| Consultation Response from Chris Bembridge KC, Highways Development Management |
| 2023/90714 Land west of, Wesley Avenue, Netherthong, Holmfirth, HD9 3UL |
| Reserved matters application pursuant to previous outline permission 2020/91146 for erection of residential development of 35 dwellings |
| Date Responded: 30/06/23 Responding Officer: CNB Responding Ref: K3-38/2 |

client	HEYWOOD HOMES LTD		
project	SITE OFF WESLEY AVENUE NETHERTHONG HOLMFIRTH HD9 3UL		
drawing	PROPOSED SITE SECTIONS D - J		
revision	notes	date	drawn
A	SECTION J ADDED	05.23	MG
scale :	1:250 AT A1	01.23	PB
project no.	2232	drawing no.	19
		revision	A

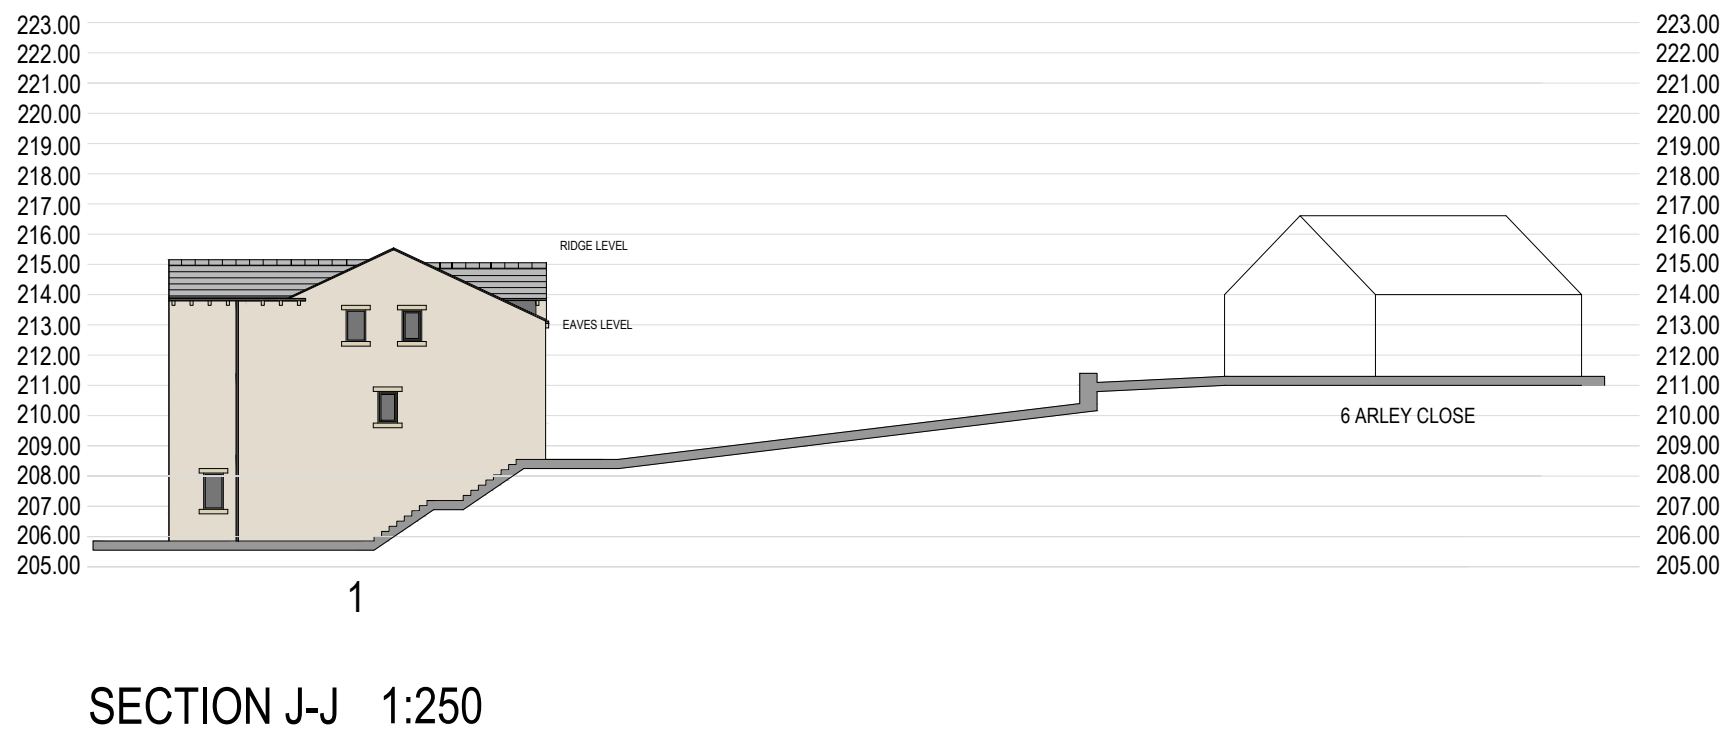
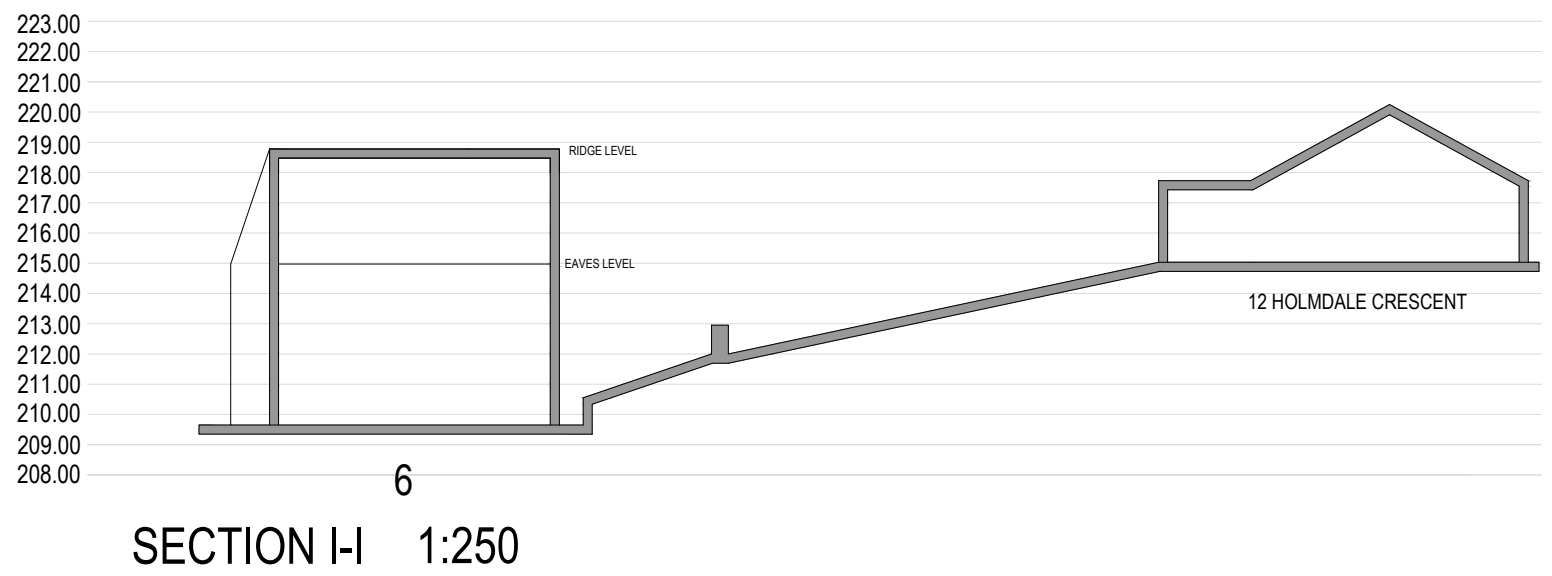
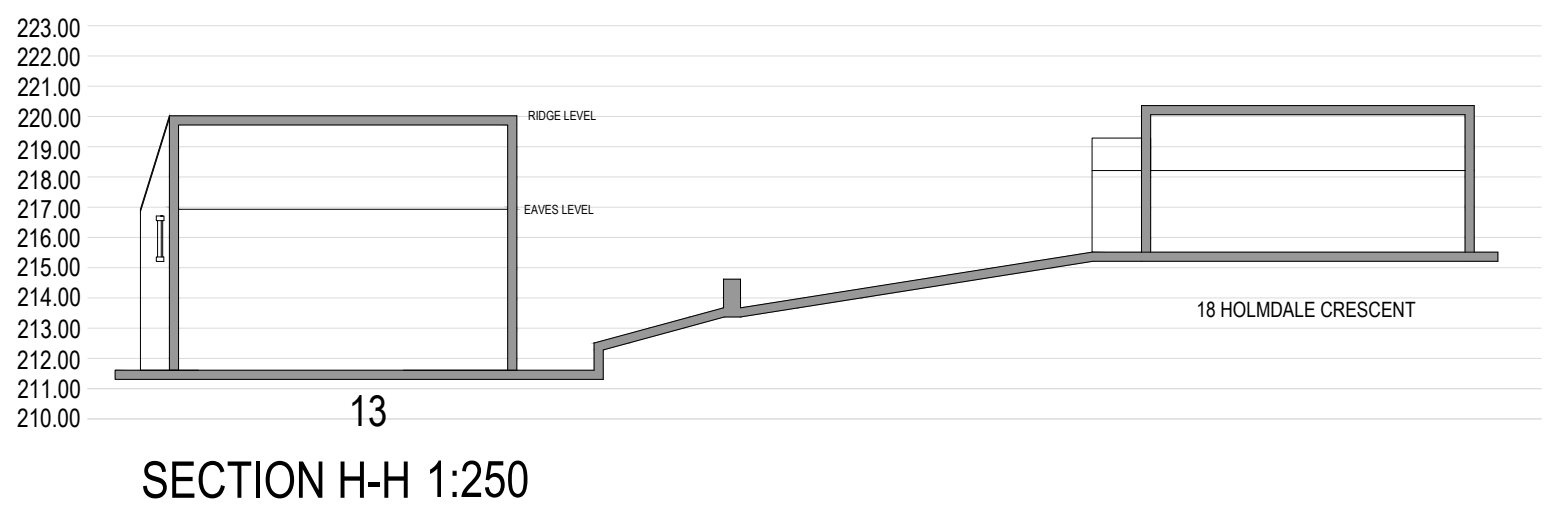
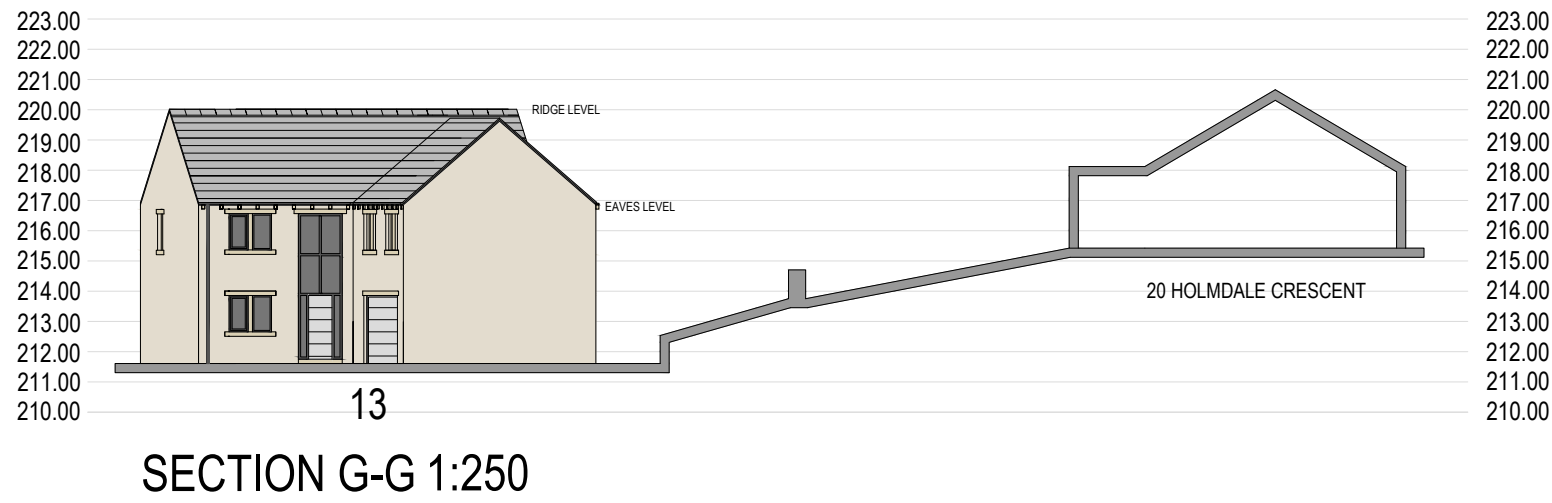
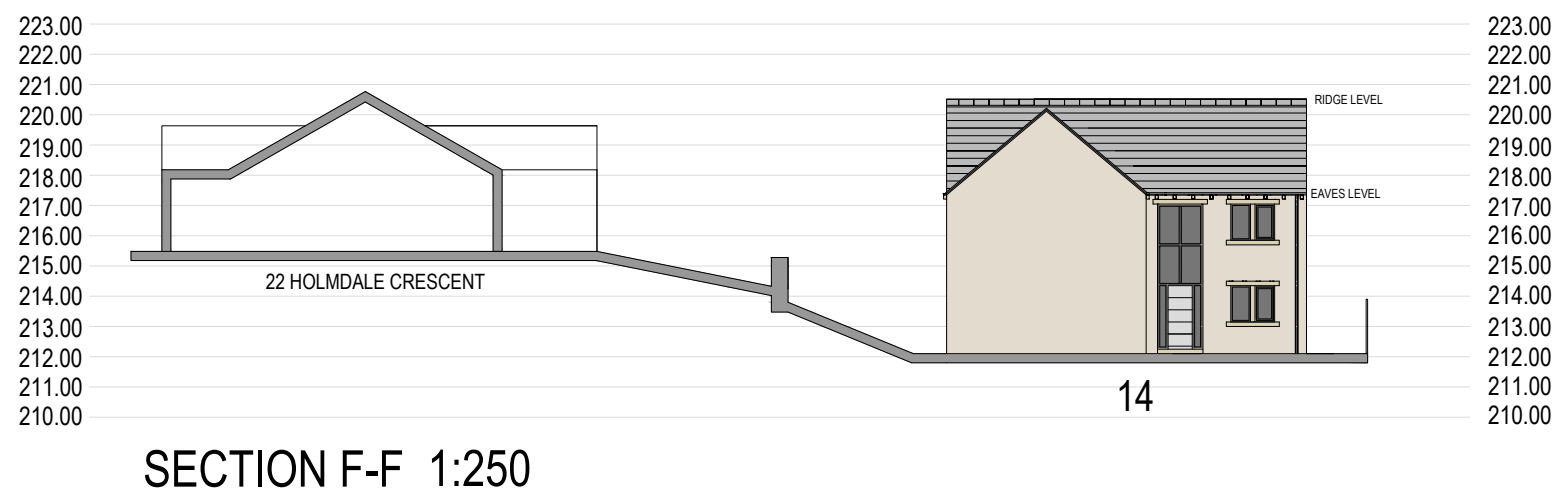
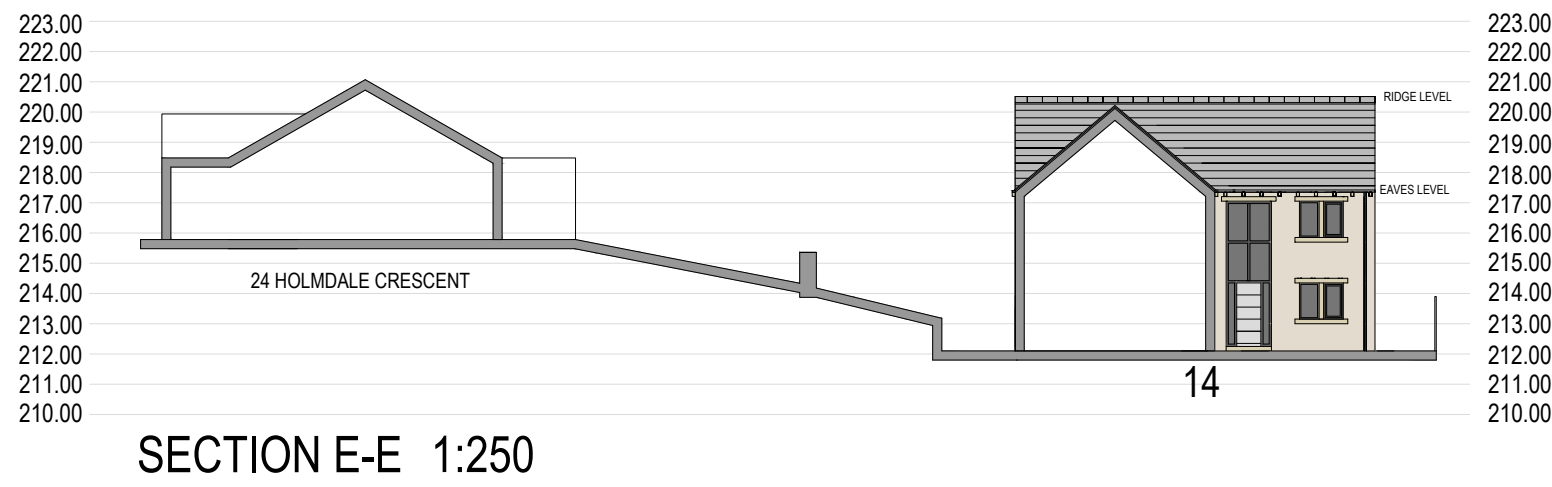
The turning head is set at a slight gradient with drawing No 19 Rev B showing it as a 1:16 gradient heading downhill to the north of the site. Although we would prefer the gradient to be 1:20 or less, we

understand that the constraints of the site cannot allow this and so we would reluctantly accept this 1:16 gradient.

The 1:16 gradient also extends into the shared surface private drive access to plots 13 to 16. For a shared surface the gradient should be no more than 1:16 before a segregated footway would be required. As the gradient is approximately 1:16 this would be just acceptable as proposed.
